Kirklees Council

Date: 19 February 2025

Application Reference: 2024/91998

**Site: ALMONDBURY SPORTS CENTRE, ALMONDBURY SPORTS CENTRE ALMONDBURY
HD5 8PQ**

DRAWING TITLE:
Landscape Illustrative Masterplan

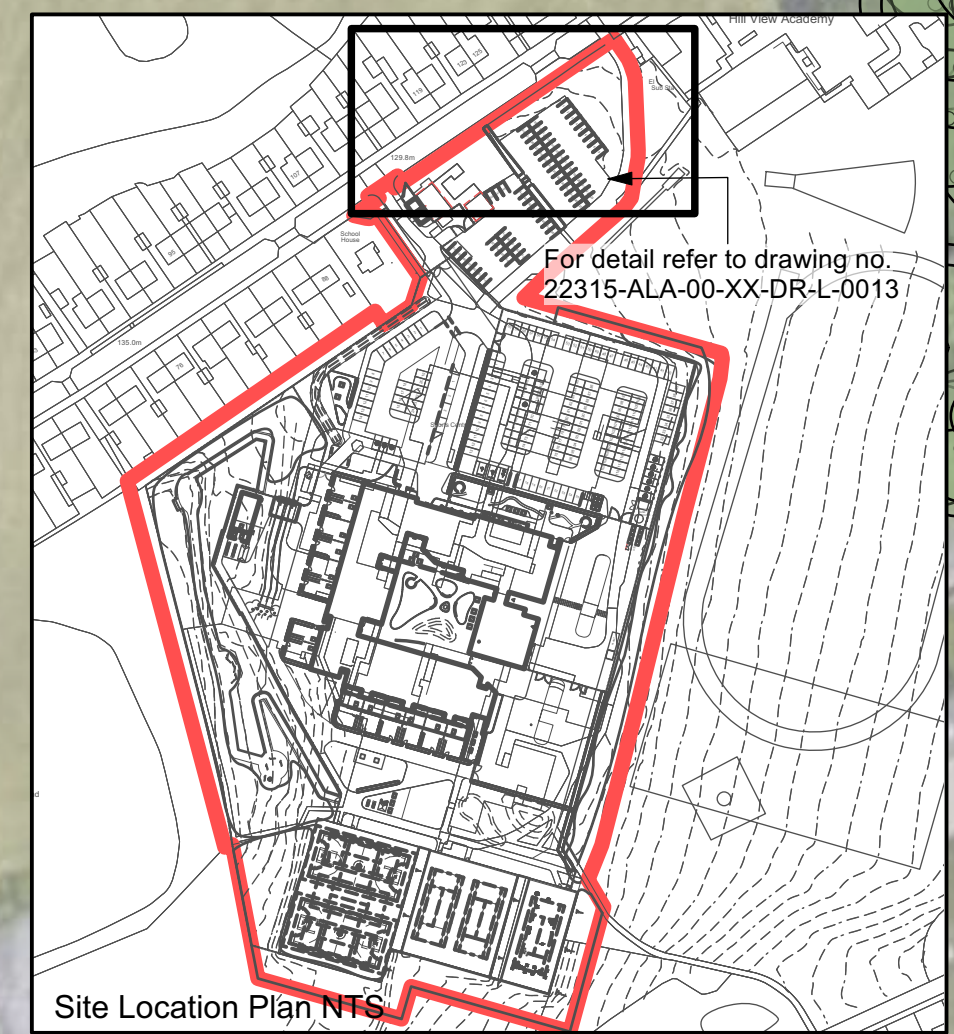
No development on the area of land as annotated as GG, T, H, P and N on the Landscape Illustrative Masterplan, drawing number 22315-ALA-00-XX-DR-L-0001 shall take place until full details of the design, location and specification the ball stop mitigation, including details of the management and maintenance responsibilities, as set out in the document titled Shelf Woodley School and College Cricket Ball Strike Assessment, Report Number LSUK.24-0605_CBA, Version 3.0 and the document titled 'Ball Stop Netting Layout', have been submitted to and approved in writing by the Local Planning Authority, after consultation with Sport England. The approved ball stop mitigation shall be installed in full before the development annotated as GG, T, H, P and N on the Landscape Illustrative Masterplan is first commenced, and the ball stop mitigation will be managed and maintained in accordance with the approved details thereafter.
